From: Laura Gibbons <Laura.Gibbons@arun.gov.uk>
Sent: 14 September 2021 10:53
To: Planning.Responses <Planning.Responses@arun.gov.uk>
Cc: Simon Davis <Simon.Davis@arun.gov.uk>
Subject: RE: Planning Consultation on: AL/112/21/DOC

Thank you for consulting us regarding this discharge of conditions application, we have the following comments on conditions 10-12.

Application No: AL/112/21/DOC
Registered: 31st August 2021
Site Address: Springfield Hook Lane Aldingbourne PO20 3TE
Description of Works: Approval of details reserved by condition imposed under AL/64/20/PL relating to conditions 10-surface water drainage, 11-discharge of flows & 12-surface water drainage system maintenance & management.

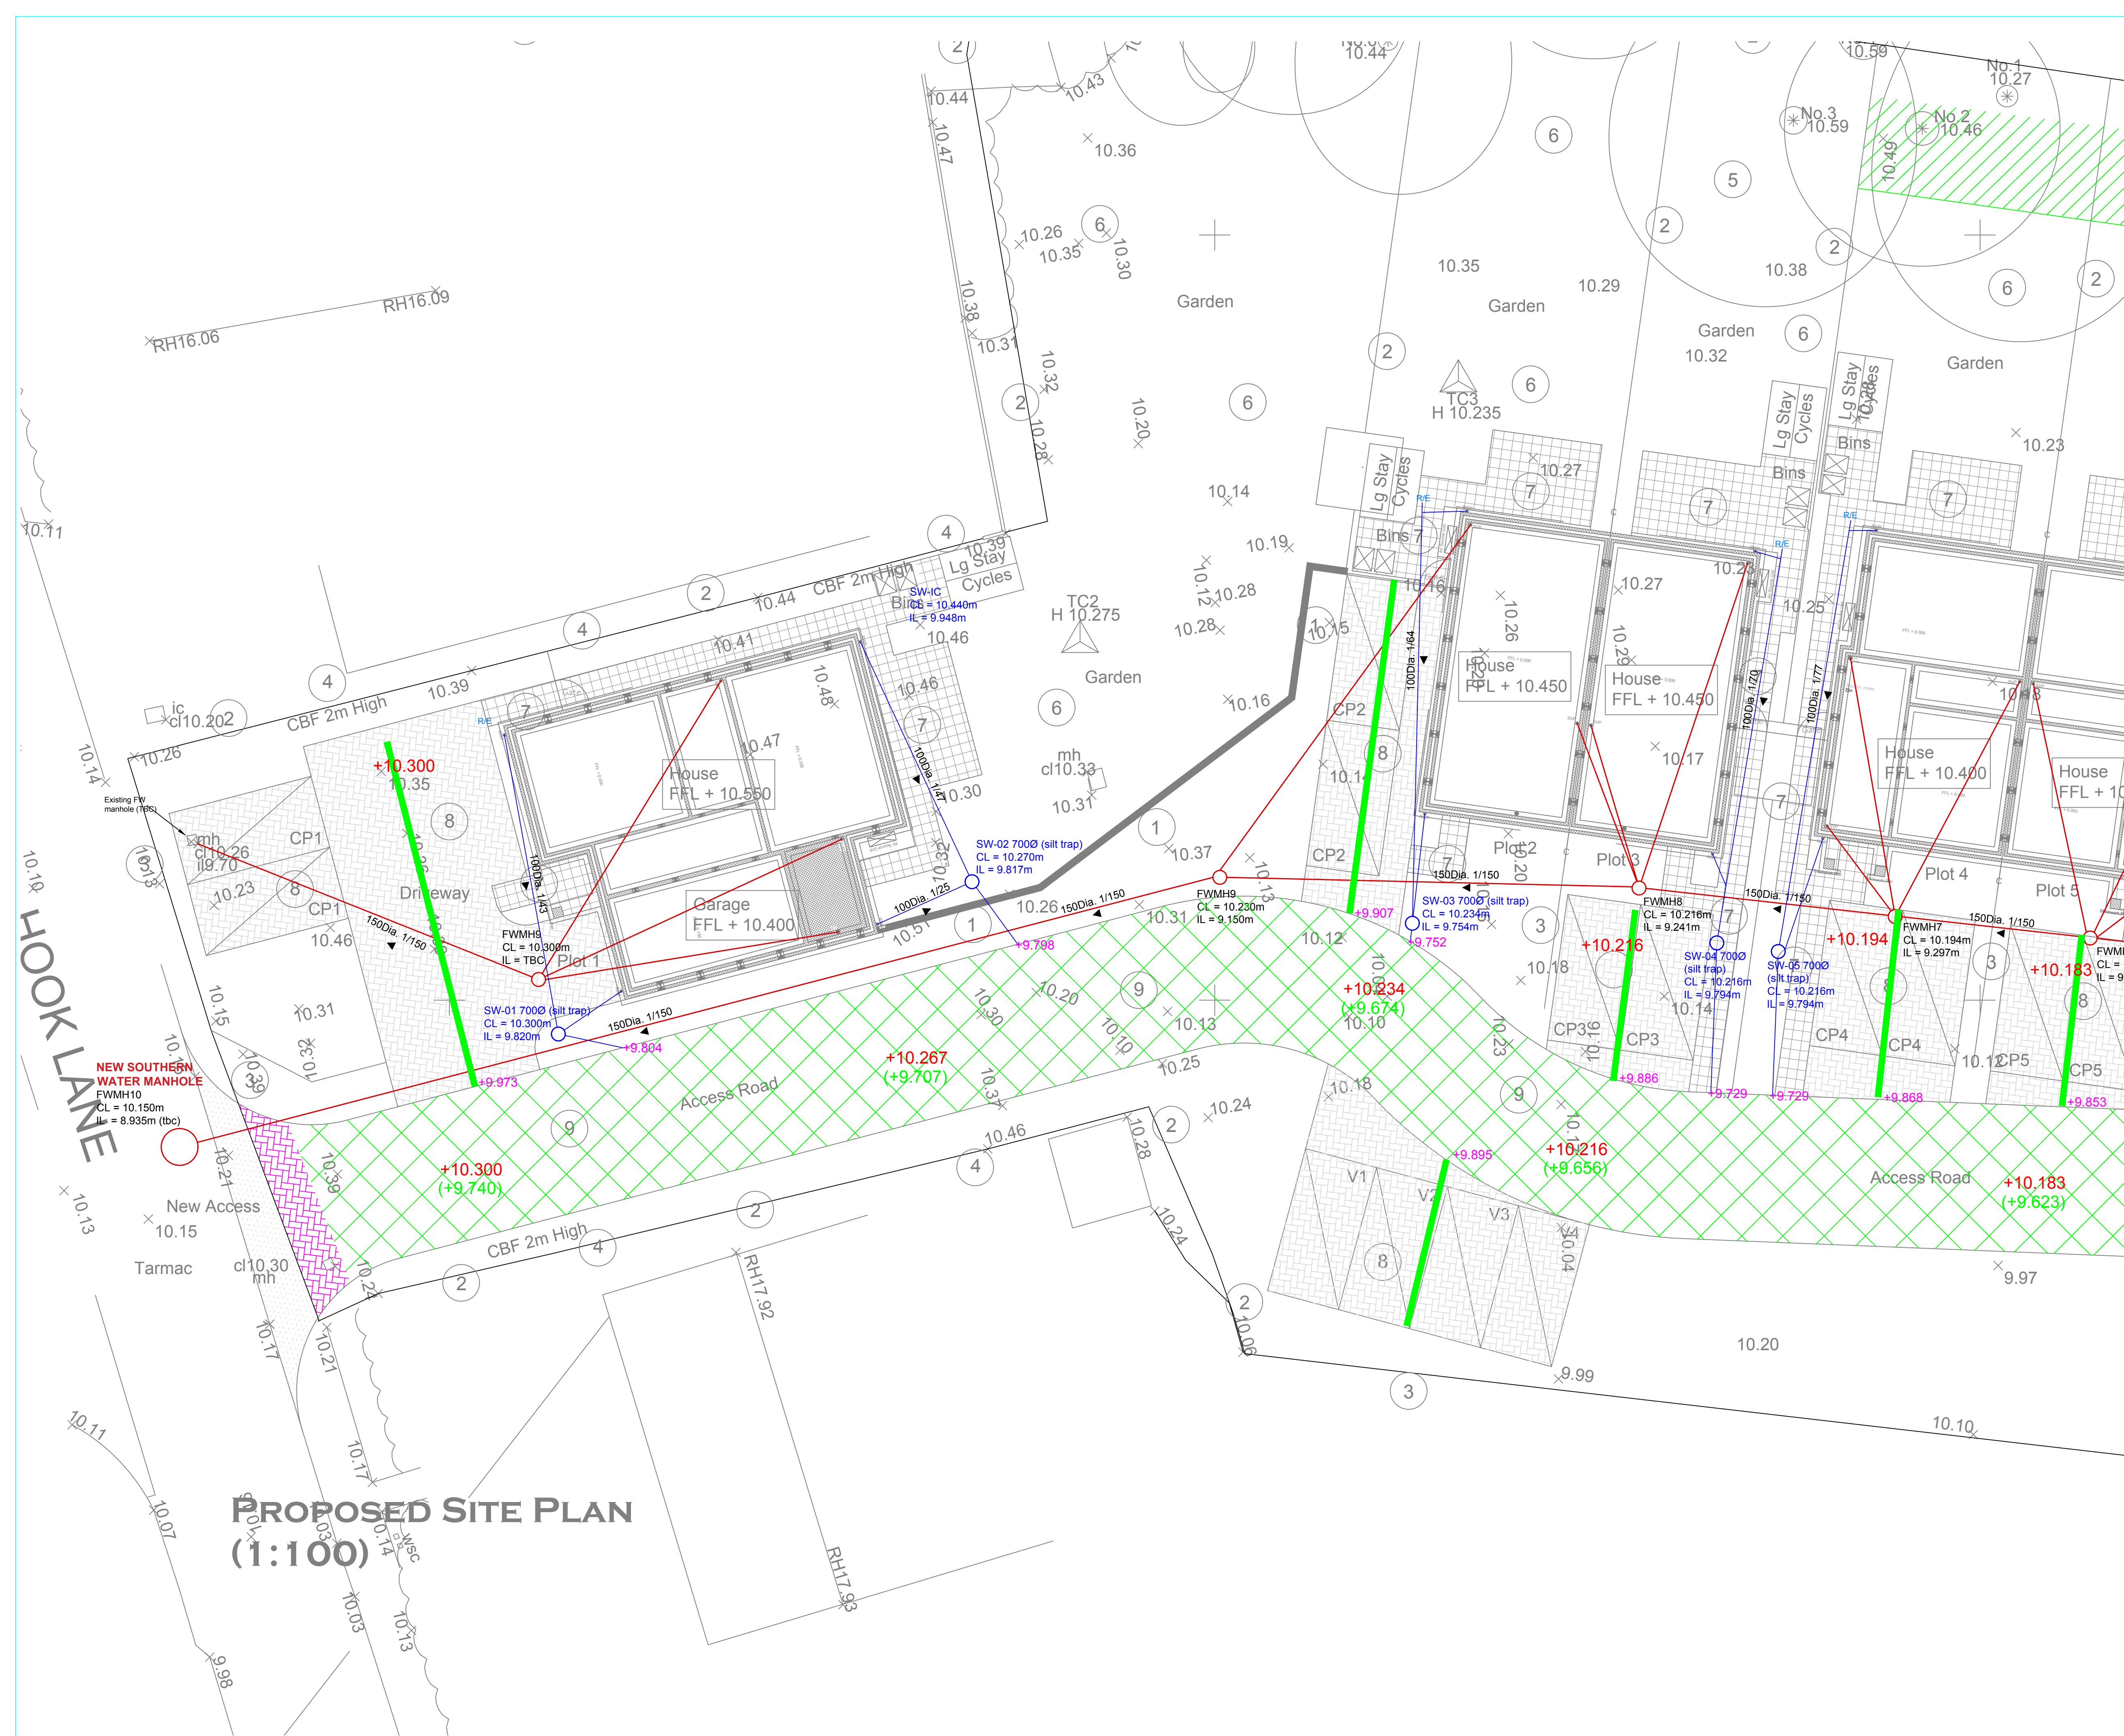
5. Finish and formation level of permeable paving in driveways should be shown on plan.
6. 100mm diameter pipework in driveway sub-base must be labelled to show slope, i.e. please provide invert levels at head of runs too.

7. Incoming pipes into permavoid are too high in some locations. For example at A-A incoming pipe invert level is 9.82m, 100mm diameter pipe gives a soffit level of 9.92mAOD which is above the top of the permavoid. Please examine and adjust layouts as required.

**(SECTION A-A) - SECTION THROUGH JUNCTION BETWEEN
 TANKED PERMEABLE PRIVATE DRIVEWAY AREAS AND PERMEABLE
 ACCESS ROAD WITH PERMAVOID SUB-BASE
 REPLACEMENT ATTENUATION SYSTEM**

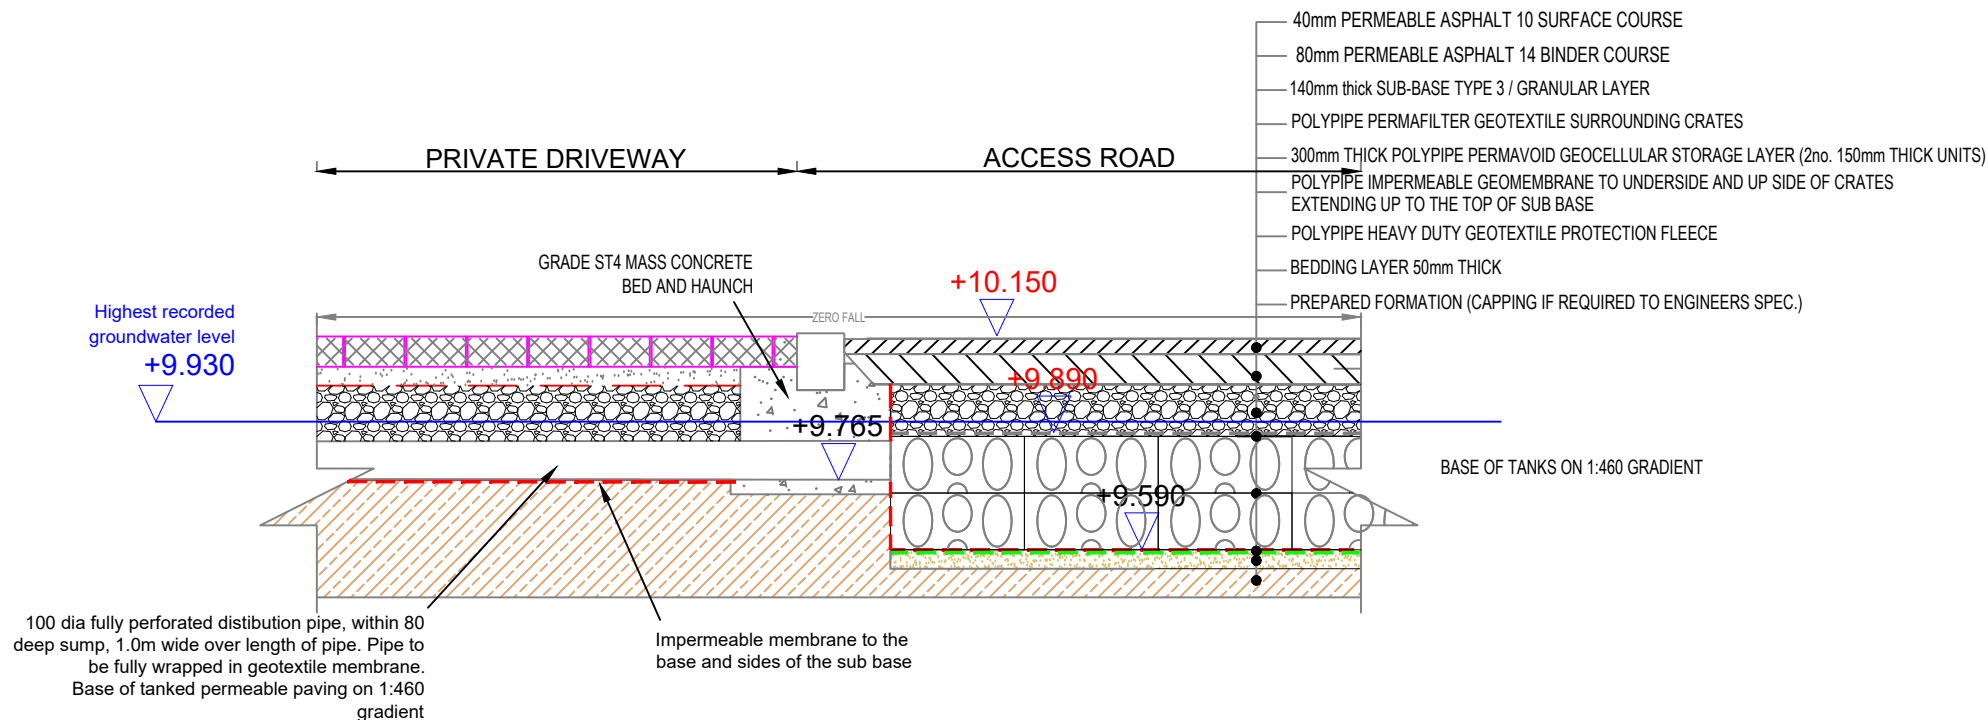
8. Please change line types on permeable paving details to clearly show impermeable liner. Currently the same line type is used above and below the permavoid, and not around the sub-base sides. Just going on line type it appears you are proposing an impermeable liner above and below the permavoid.
